Re: 2600 Menaul NE (Applebee's Menaul)
Letter of Architectural Certification submitted for final Certificate of Occupancy

Re: Certification Submittal for Final Building Certificate of Occupancy for
Applebee's Restaurant, [K09 / D019]
2600 Menaul NE
Architect's Stamp Undated

Re: T.C.L. submittal for building permit approval for Applebee's,
2600 Menaul Blvd. N.E. [H16/D133,
Architect Stamp dated 7/10/2001.

**RE: APPLEBEE'S, MENAUL & VASSAR NE (H16-D133). GRADING AND DRAINAGE
PLAN FOR BUILDING PERMIT APPROVAL. ENGINEER'S STAMP DATED
MAY 1, 2001.**

RECEIVED
MAY 01 2001
HYDROLOGY SECTION
APPLEBEE'S - MENAU & VASSAR
GRADING & DRAINAGE PLAN

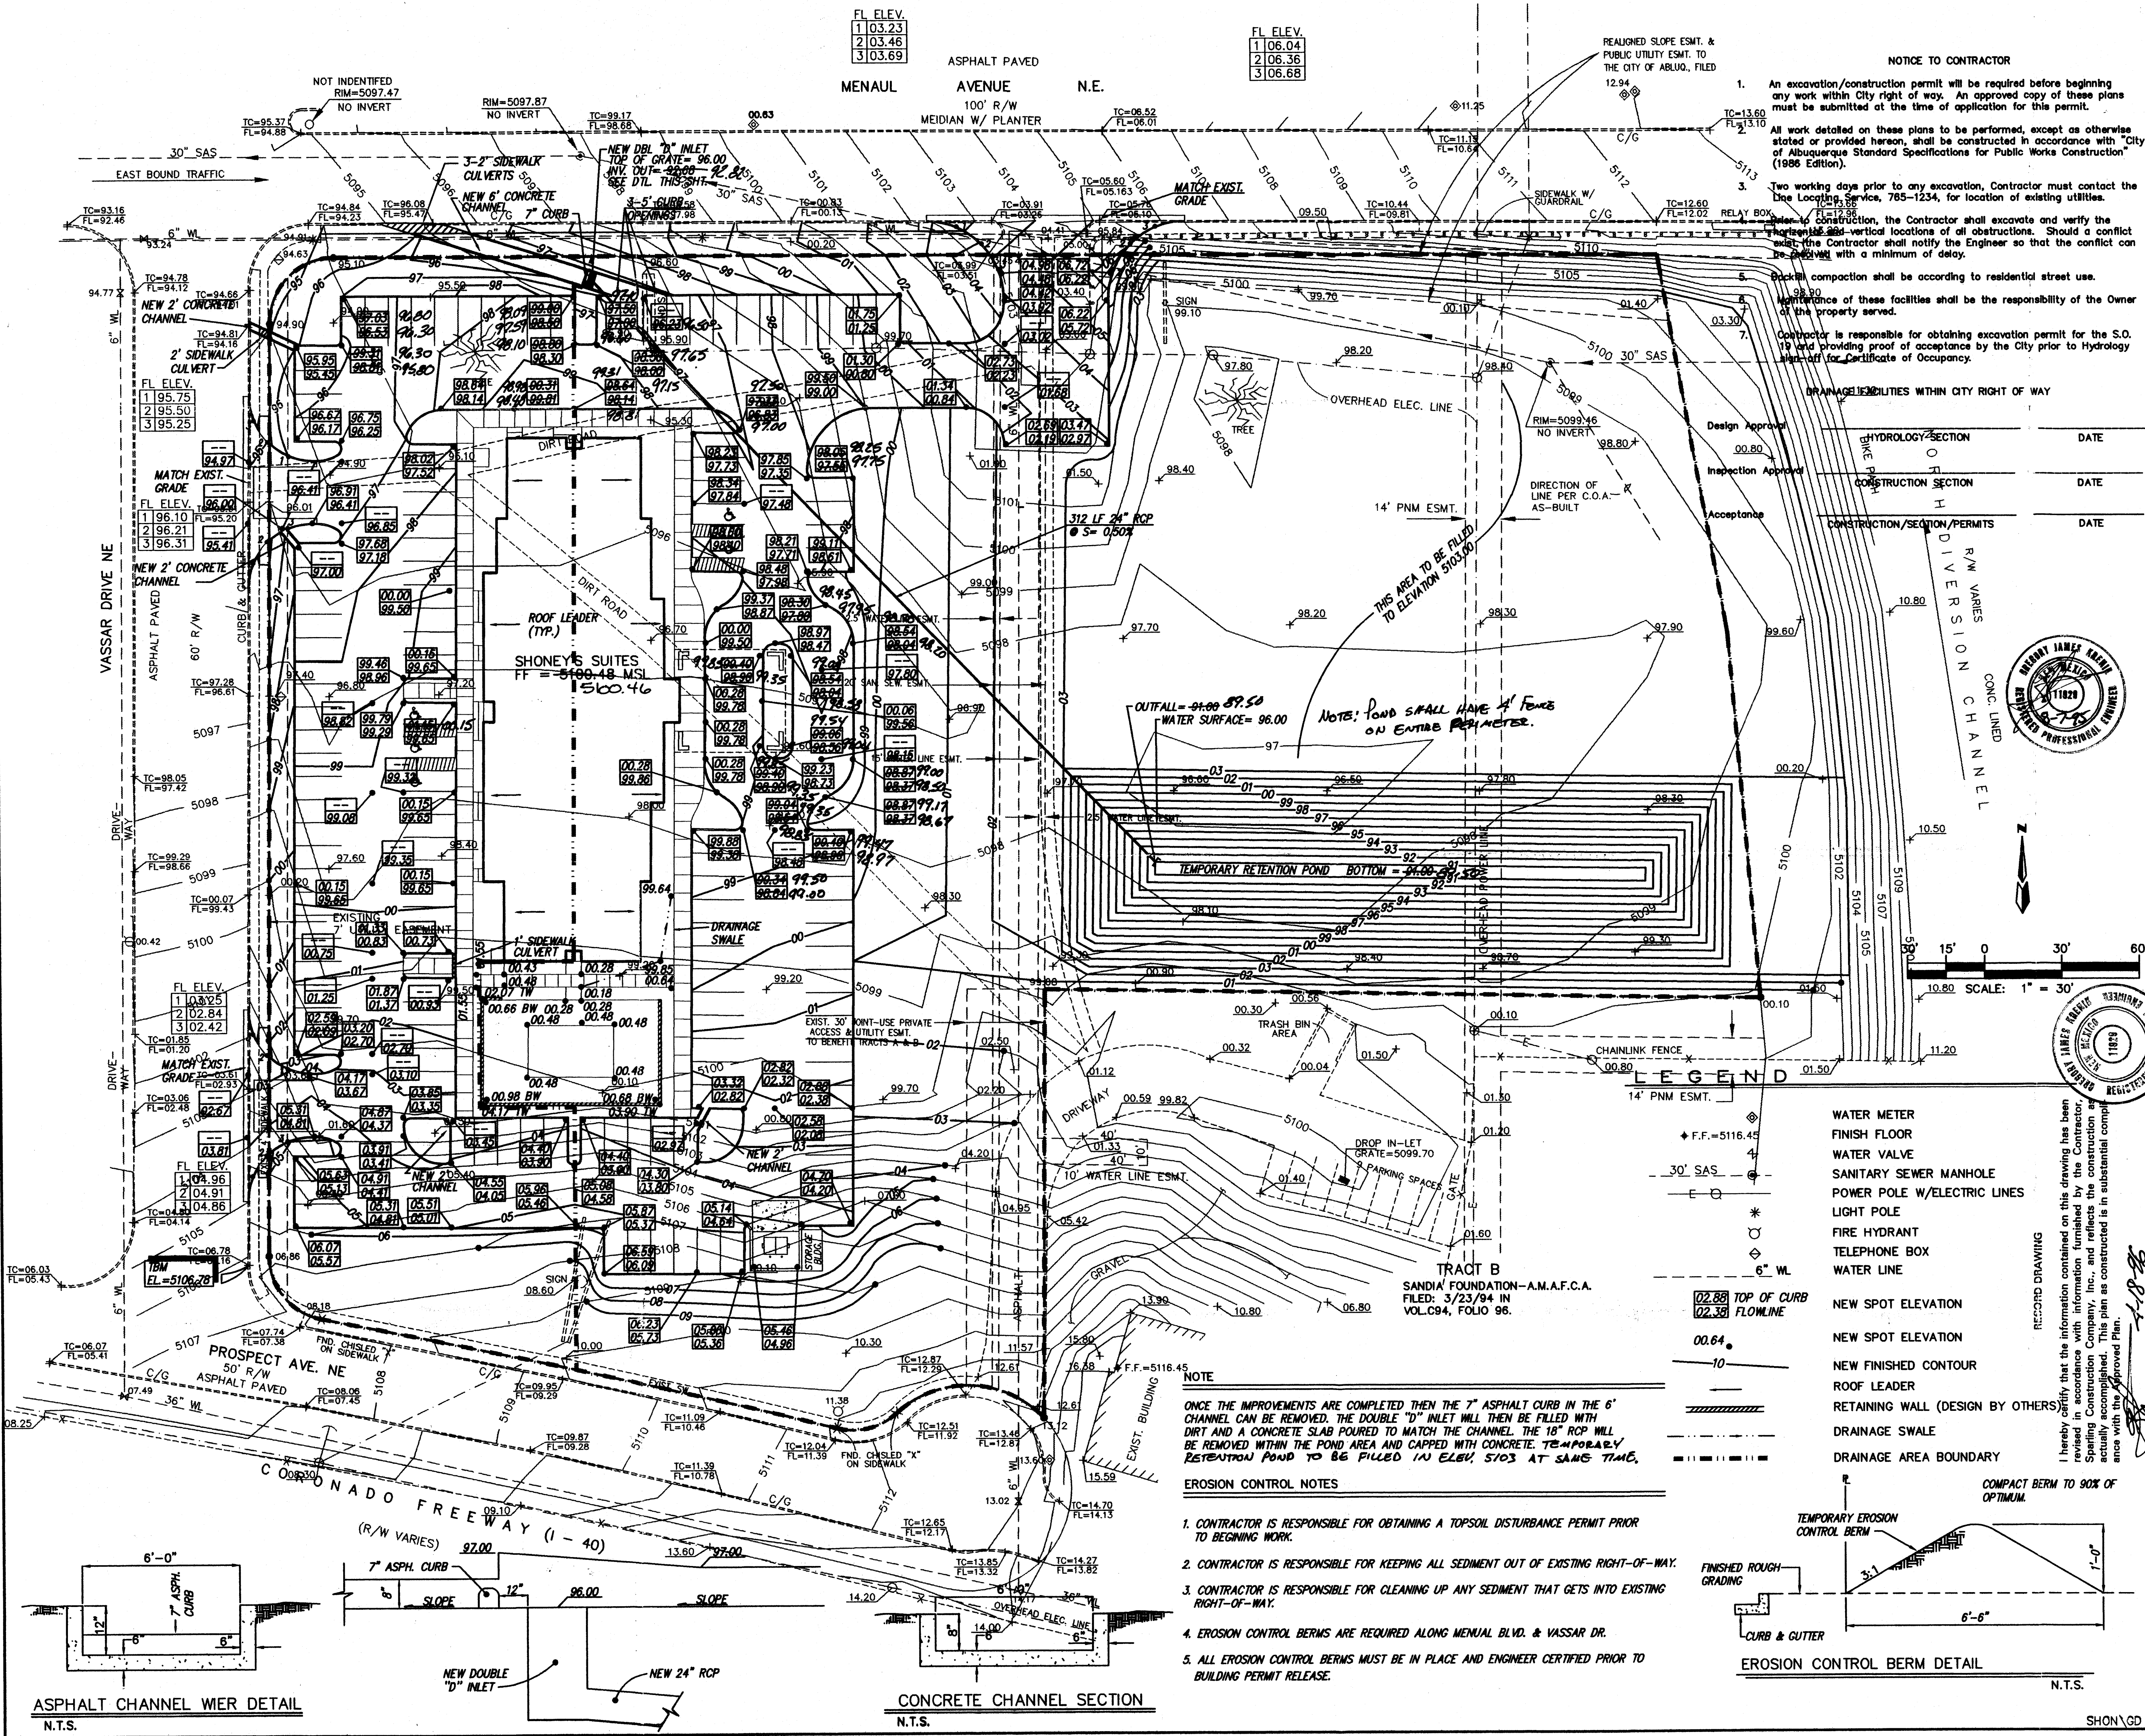
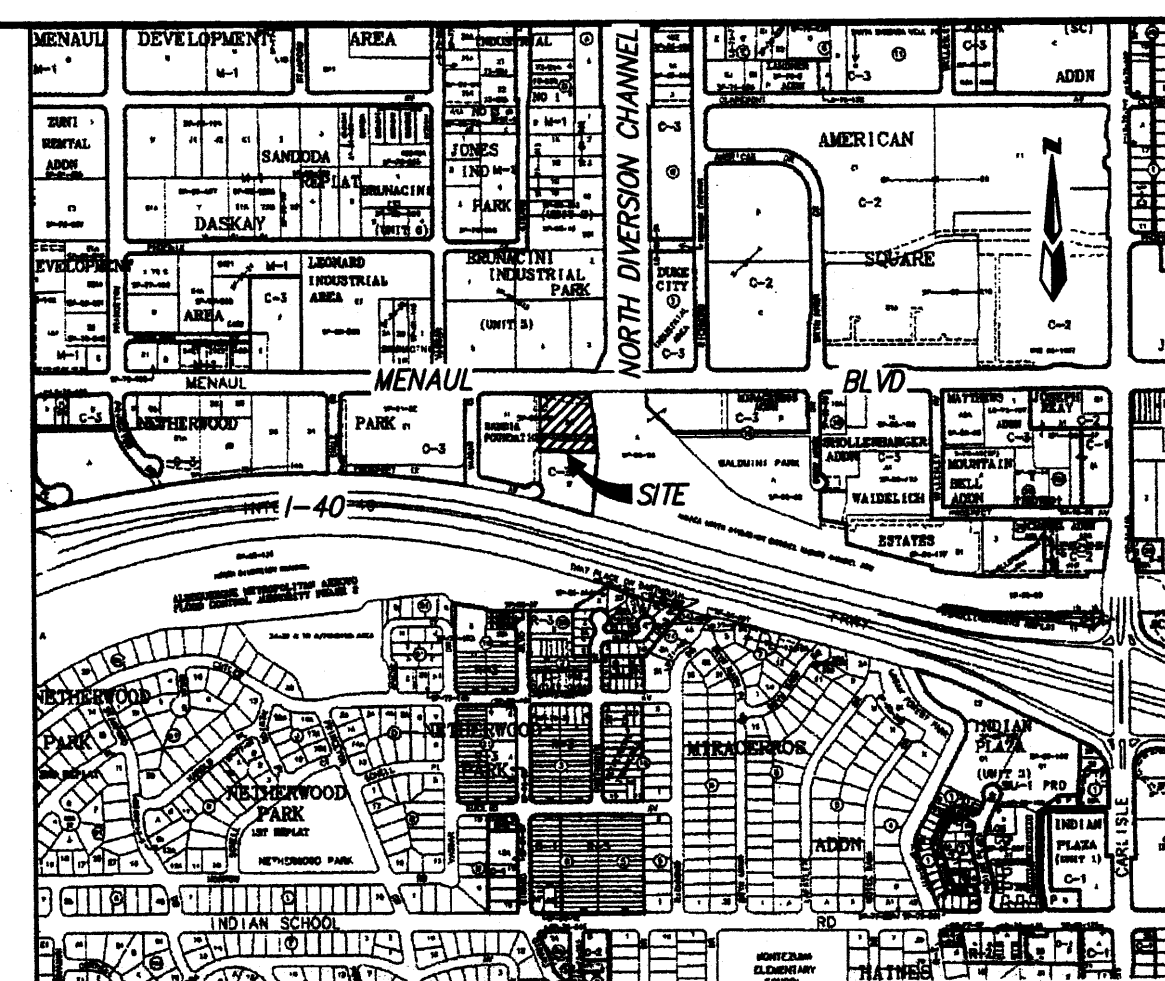
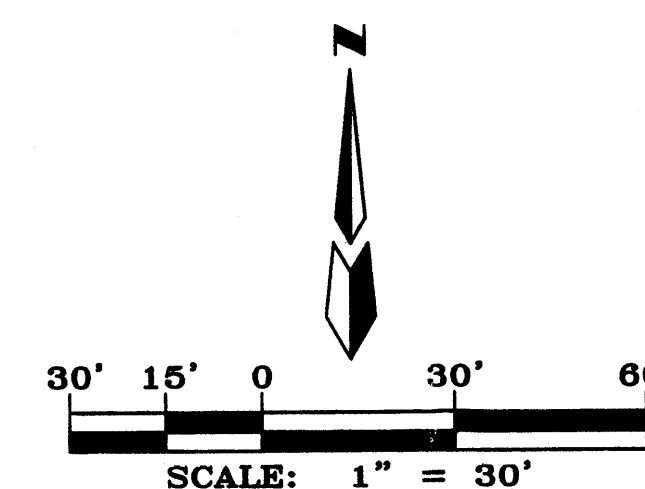
The drainage easement between the hotel and restaurant should be executed prior to issuance of the Building Permit itself. Note states concrete channel is 7.5 feet wide; detail says varies.
